# **BATTERY BOX WHITEHALL BOX ENERGY STORAGE SYSTEM**

**VARIATION OF CONDITION SUBMISSION**

Name and Address of Applicant: Amanda Fairman
AMP Clean Energy 1, Dover Street London W1S 4LD
Address: Land At Whitehall/Belchmire Lane Gosberton Spalding
Date of application: 28 <sup>th</sup> May 2024
Application Number: H08-0469-24
Local Planning Authority: South Holland District Council
Description of the Proposal: Construction and operation of a micro energy storage facility
Date of decision: 19th September 2024

This submission seeks to make a non-material amendment to condition 2 and 3.

BATTERY BOX
BATTERY EQUIPMENT

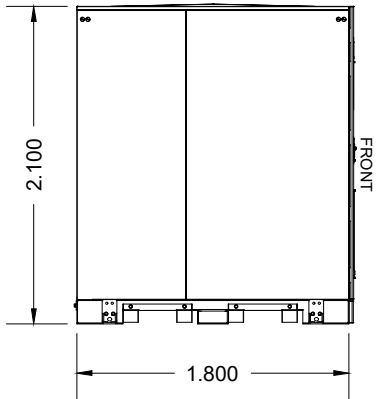
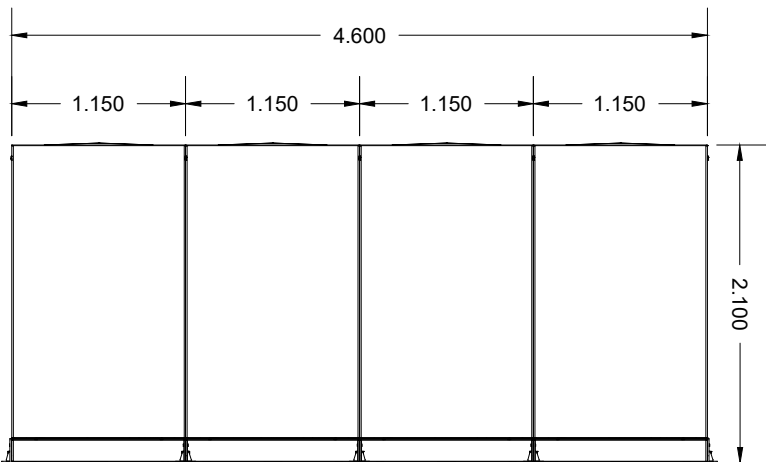
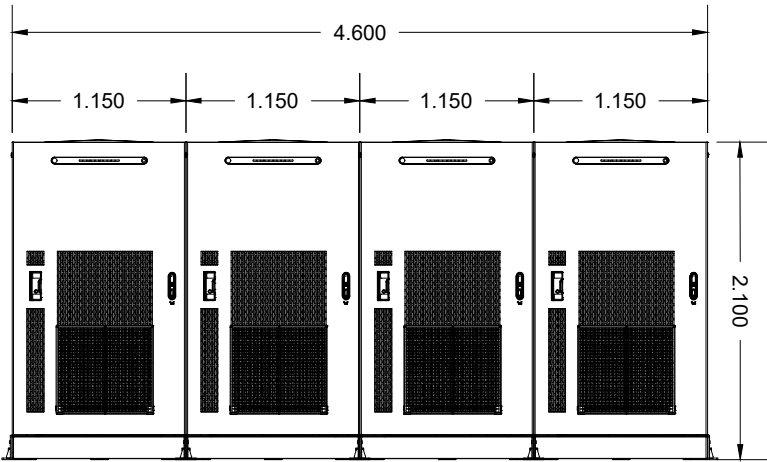
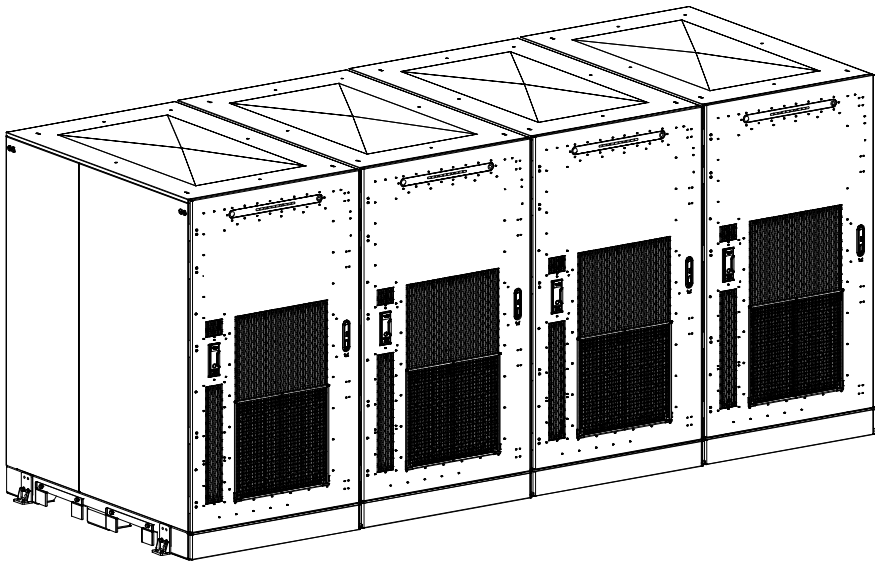
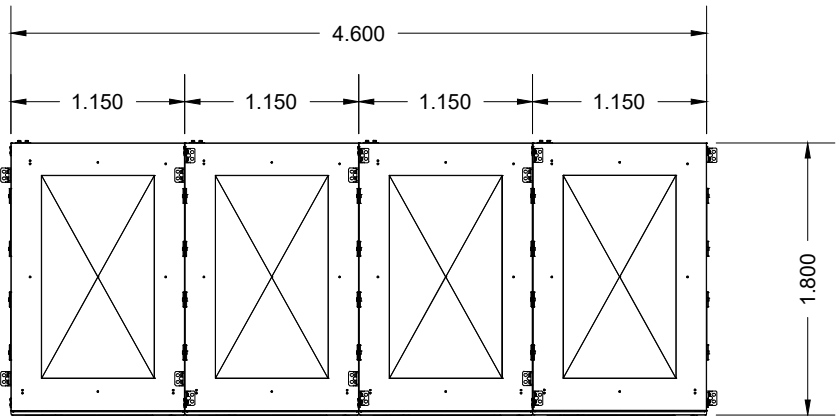
This application now seeks to amend condition 2 and 3 of that permission, which relates to the approved plans. The primary change concerns the design and specifications of the Battery Box, as the project now involves a different Original Equipment Manufacturer (OEM).

Consented Scheme	Proposed Amendments
Total footprint (LxW) Sqm	$6.05m * 3.90m = 23.60m^2$	$6.40m * 3.90m = 25.00m^2$
Battery Unit Height	2.78m	2.41m
Fence Type	Paladin - 20 m Perimeter	Paladin - 9.99 m Perimeter
Battery Units/PCS/Electrical Cabinet	2 Battery units 1 PCS 1 Electrical Cabinet	4 Battery Units (PCS Included) 1 Electrical Cabinet

Plan Submitted with original application	New Plan
02 - Site Layout Plan	02 – Site Layout Plan NMA Oct 2024
04 Battery Equipment – Plans and Elevations	04 Battery Equipment – Plans and Elevations NMA Oct 2024
05 Electrical Cabinet – Plans and Elevations	05 Electrical Cabinet – Plans and Elevations NMA Oct 2024
